Subject: Re:Details of Planning decision on Application Ref: FG/17/22/HH at 44A Ocean Drive

Application No: FG/17/22/HH
Site Address: 44A Ocean Drive Ferring BN12 5QP
Grid Reference: 509410 101674
Category: Householder
Description of Works: Erection of single storey rear/side extension following the demolition of existing conservatory.

Proposed Ground Floor Plan

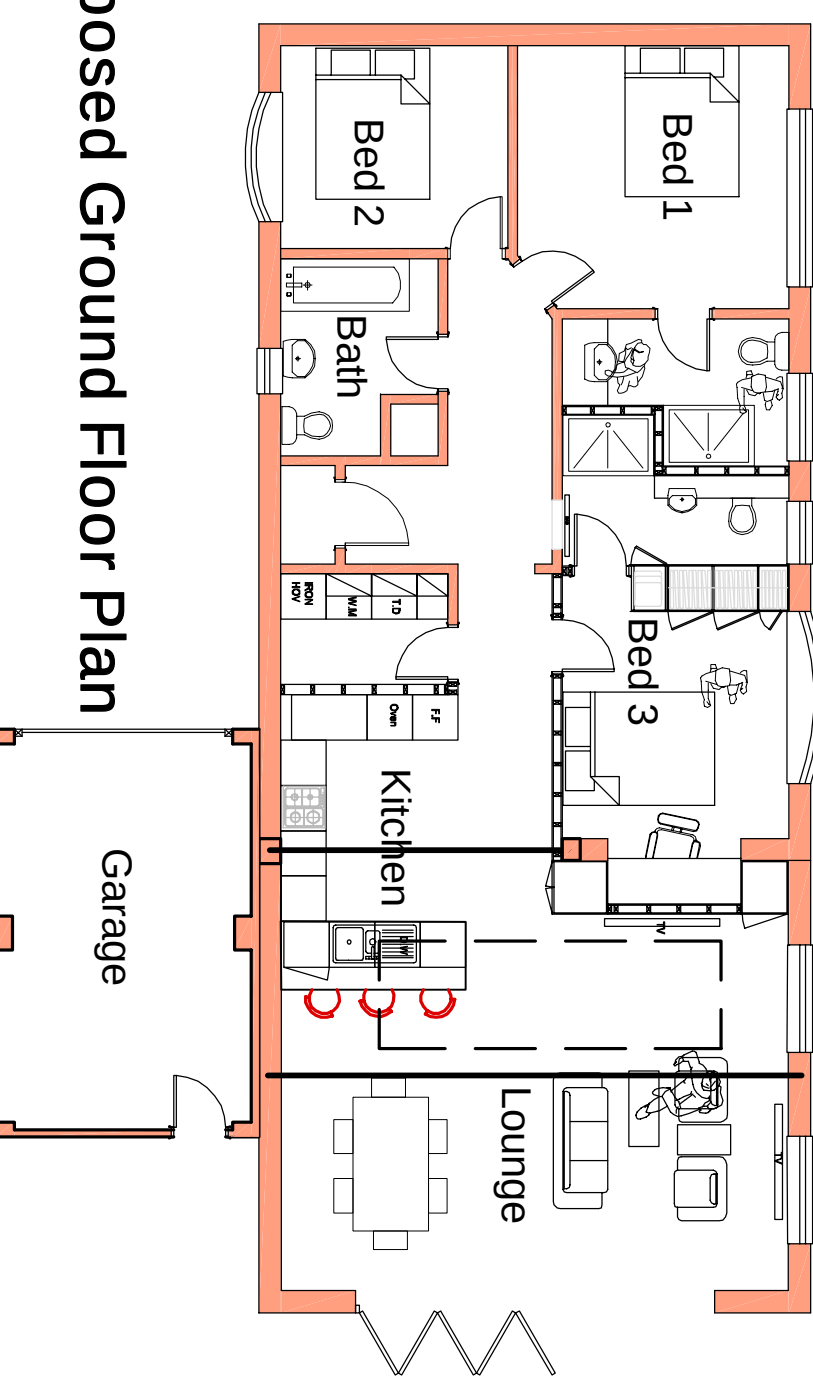
With regards to my only objection - the installation of the rear door to the garage - I believe the use of this entrance will impact on me greatly - with an increase in noise level and overlooking which will affect my privacy. Seeing the plans on paper is one thing however, if you had taken me up on my invite for a site visit to see how this will affect me then I would have had more respect for any decision made by the council.
